EP-23-0083_1 Jane Davis Ranch

El Paso County File Number SKP232

Comments uploaded to El Paso County Development Application Review on 7/2/2025:

The available referral documents include the Sketch Plan (William Guman & Associates, Ltd., May 19, 2025), Letter of Intent (William Guman & Associates, Ltd., September 16, 2024), Soil and Geology Study (Rocky Mountain Group, Amended March 20, 2024), and other documents. The applicant plans to subdivide the property into 89 single-family lots, two commercial lots, and a community park.

**Fp** - Floodplain as mapped by FEMA - this area contains wetlands and is to be a No Build Zone.

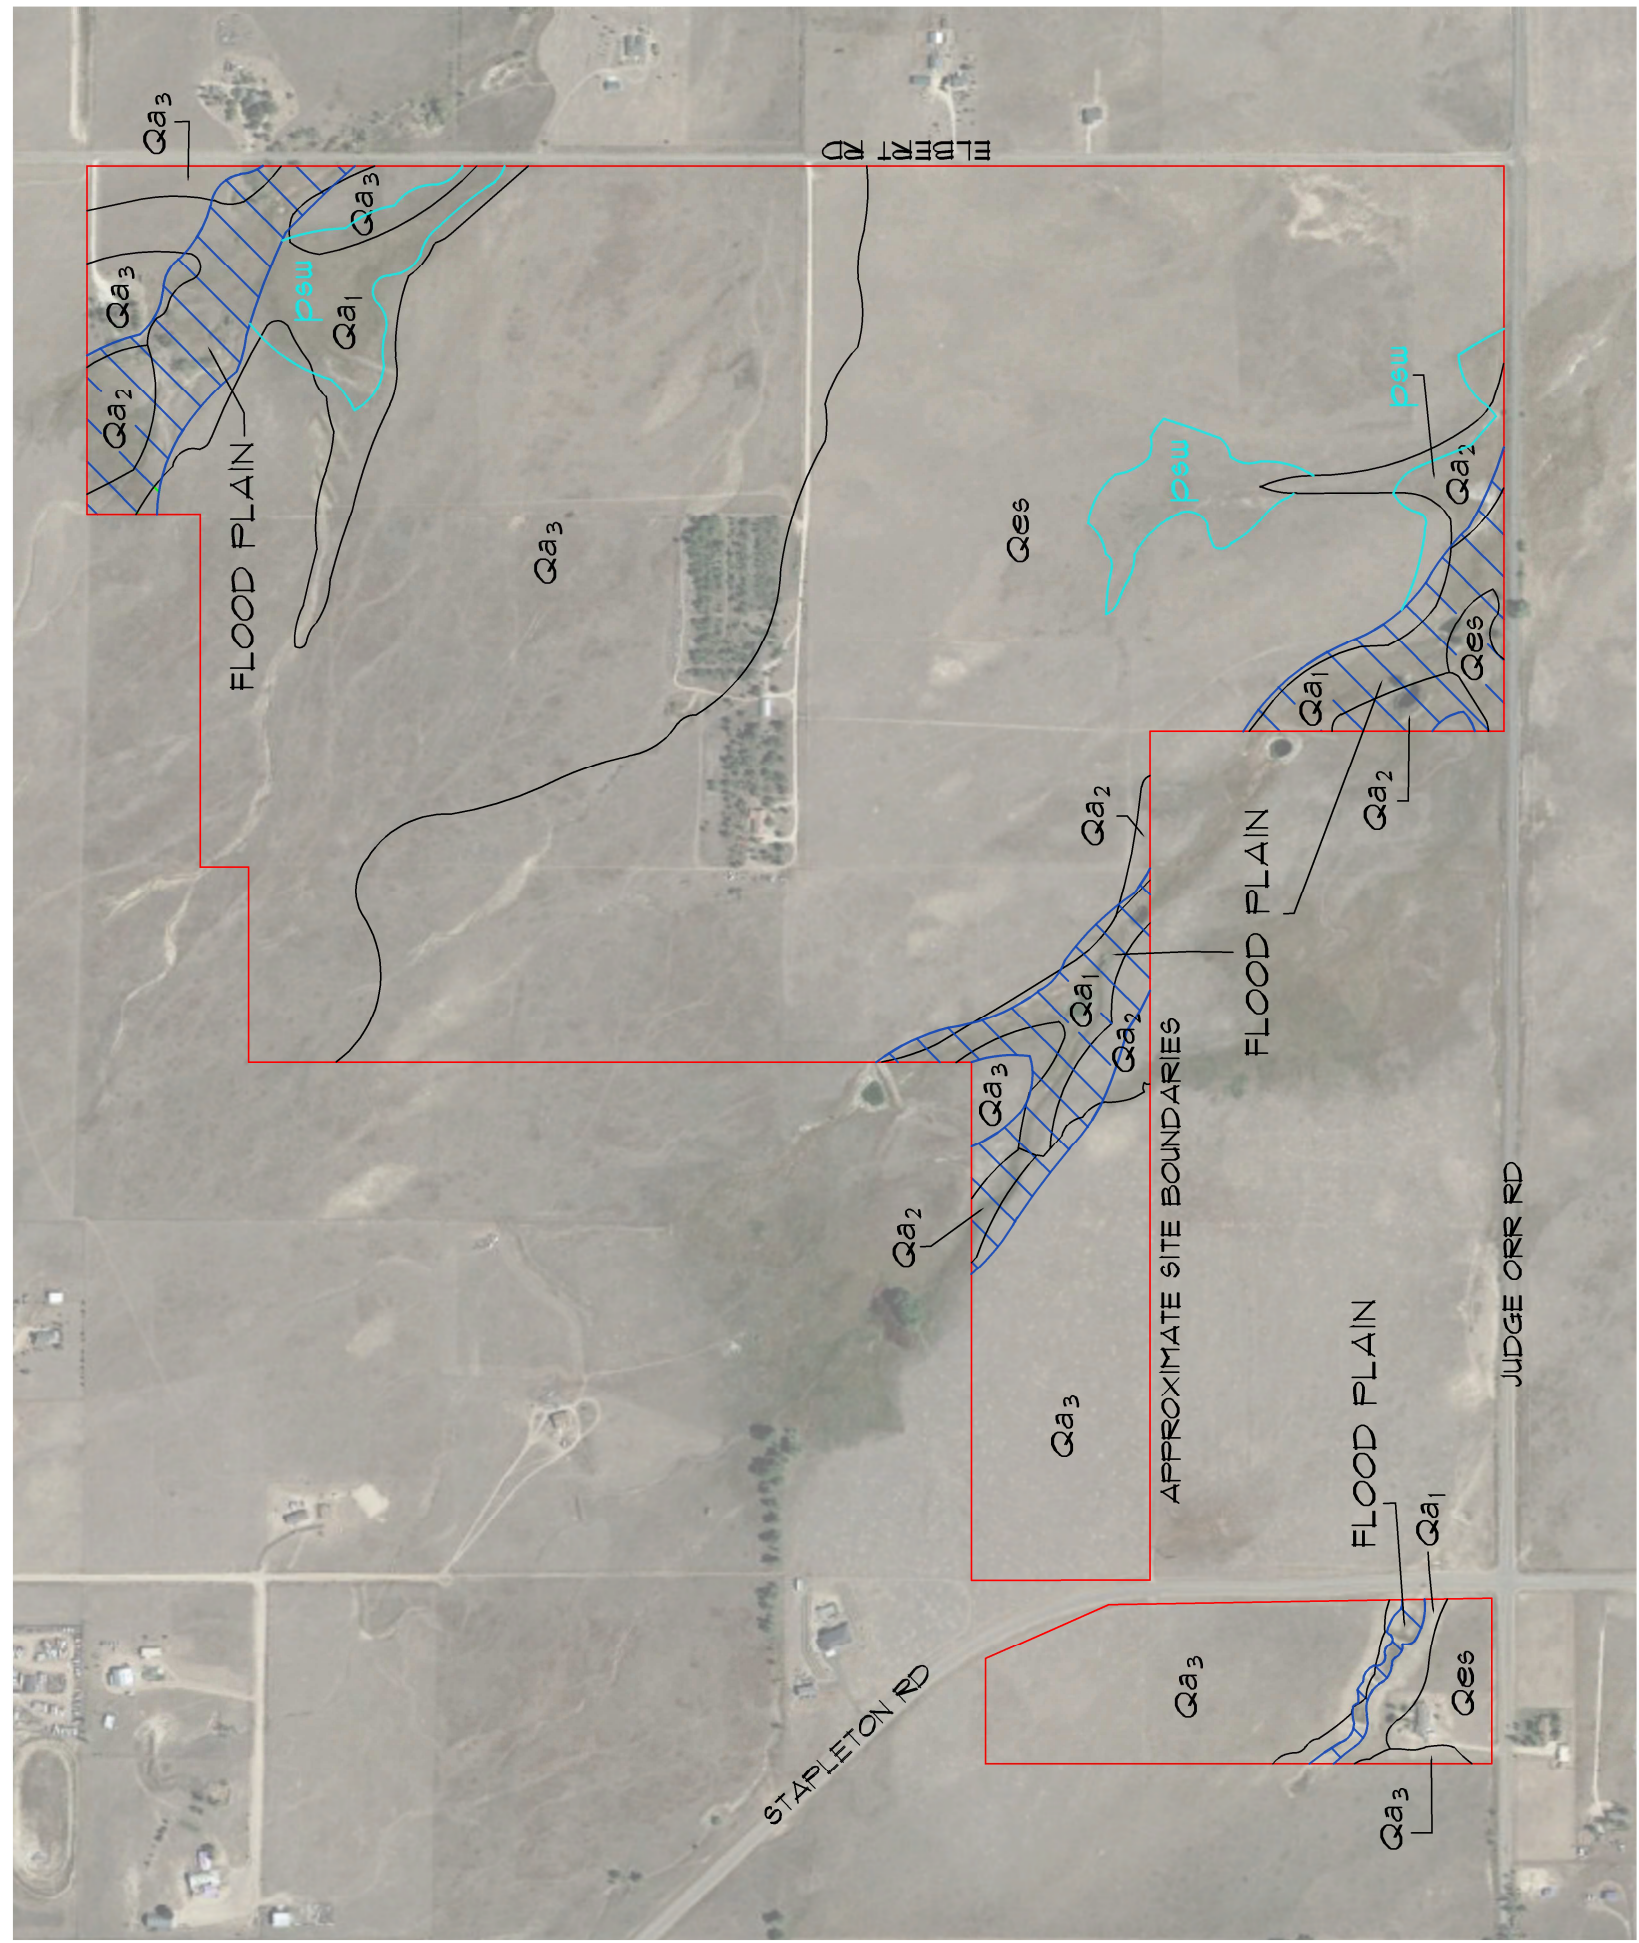
A drainage traverses a portion of the development mapped as a FEMA Floodplain (FIRM Panels: 08041C0558G, dated 12/7/2018). The development is within both Zone X and Zone A. The floodplain is designated as a No-Build Zone based on RMG's study and the sketch plan. RMG recommends *"the lowest finished floor elevation (including basement together with attendant utility and sanitary facilities) shall be elevated one-foot or more above the designated Base Floor elevation (BFE)."* **CGS recommends that an erosional non-buildable setback from the floodplain boundary should be established.**

SHEET No.  
**FIG-28**

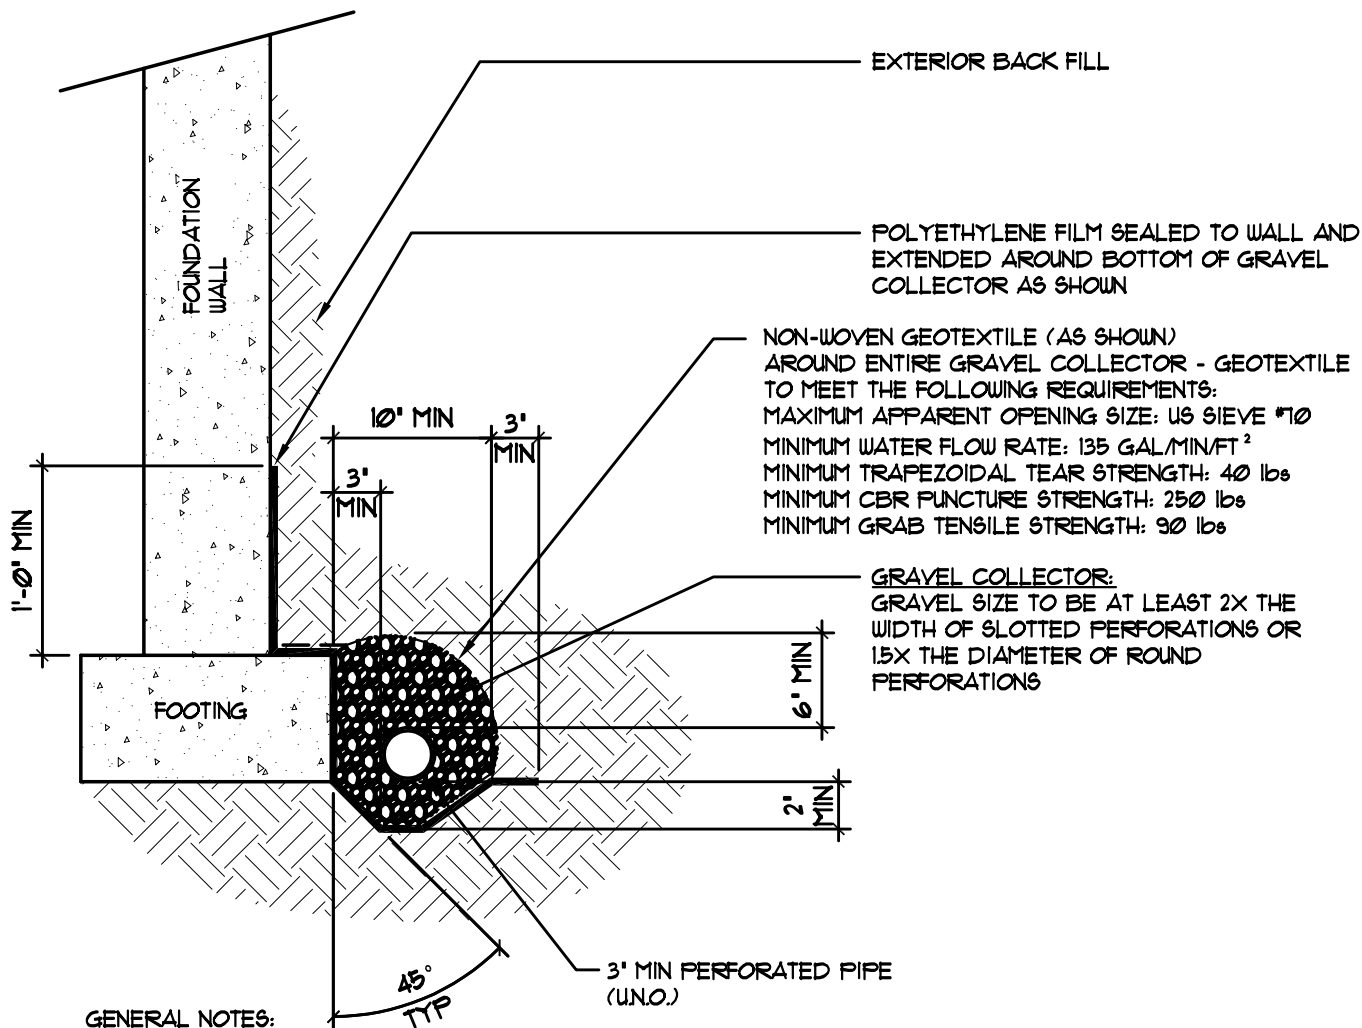
RMG recommends perimeter and underslab drains if groundwater is encountered within 4 to 6 feet of the basement slab elevation. These drain systems should be connected to an underdrain system constructed for the development. Please note that individual foundation perimeter drains are needed around any below-grade (basement) space and are intended to handle only small amounts of intermittent water and should not be used to mitigate a persistent shallow groundwater condition.
